Date: 9th October 2012
To: Planning
Cc: -
From: Miriam Hill
Subject: S6/2012/1635/FP – Twelve Apostles Church Kentish Lane Brookmans Park
Retention of Change of Use of land to create extension to existing car park and associated landscaping

I have reviewed the proposal for the above site and refer to drawing number 03a and 4 and the Arboricultural Report dated October 2012 ref 250616-CD-51b.

| Drawing Title PROPOSED EXTENDED CAR PARK AND LANDSCAPING | | |

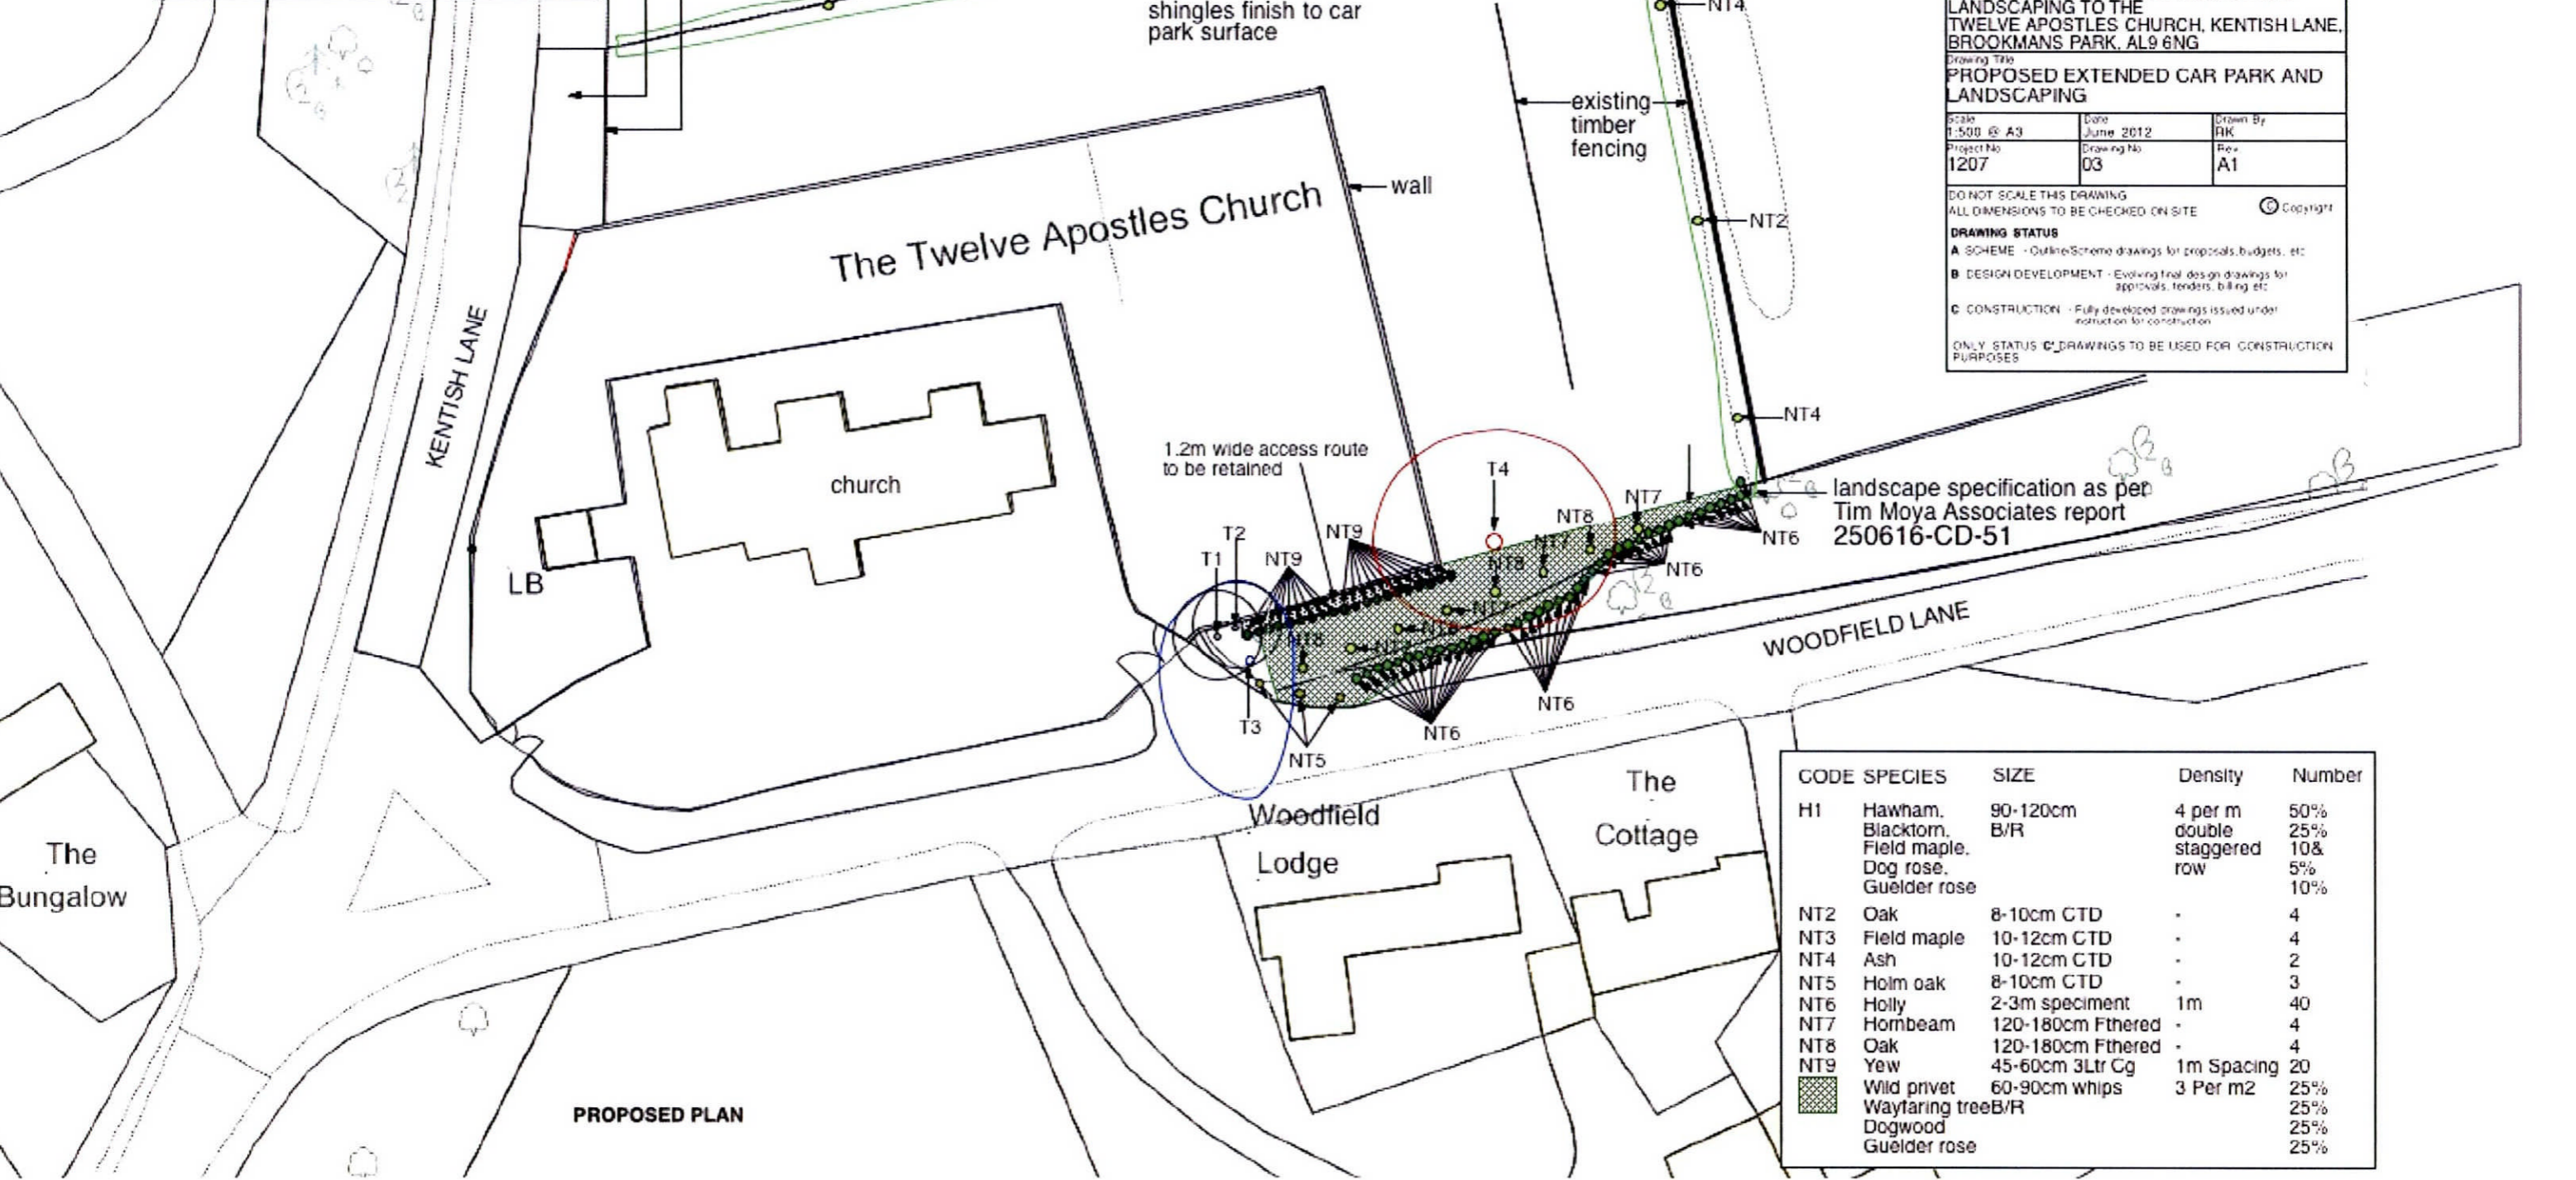
The landscape drawings show the area adjacent to Woodfield Lane planted as an informal shrubbery with trees, using native species. This will supplement the existing vegetation and trees. The majority of the roadside boundary will be planted as a holly hedge. This will produce a dense screen if kept clipped on a cyclical basis. The remaining area will be planted with a mixture of shrubs and trees. The trees are native and commonly found locally. The shrubs are native, low maintenance, ornamentals which will benefit wildlife and produce a good informal screen. If left to grow they can attain heights of 3m or more.

Around the periphery of the site, adjoining the fields, oak, ash and field maple will be planted to grow as trees. These are all species of trees commonly found in hedgerows in the area.

The area to be planted has had recent cultivation. The soil levels within the car park are

artificially low. It is suggested that a small amount of land re-profiling be undertaken with some 'spare' soil which is currently being stored on site. The planting area does have existing trees whose roots could be affected by soil level changes. Following on site discussion, a method statement (section 5 of the Arboricultural Report) has been included. This confirms that there will be on-site supervision during works and the depth of new soil under the crowns will be a cosmetic depth of 5cm. This is a reasonable approach for this location.
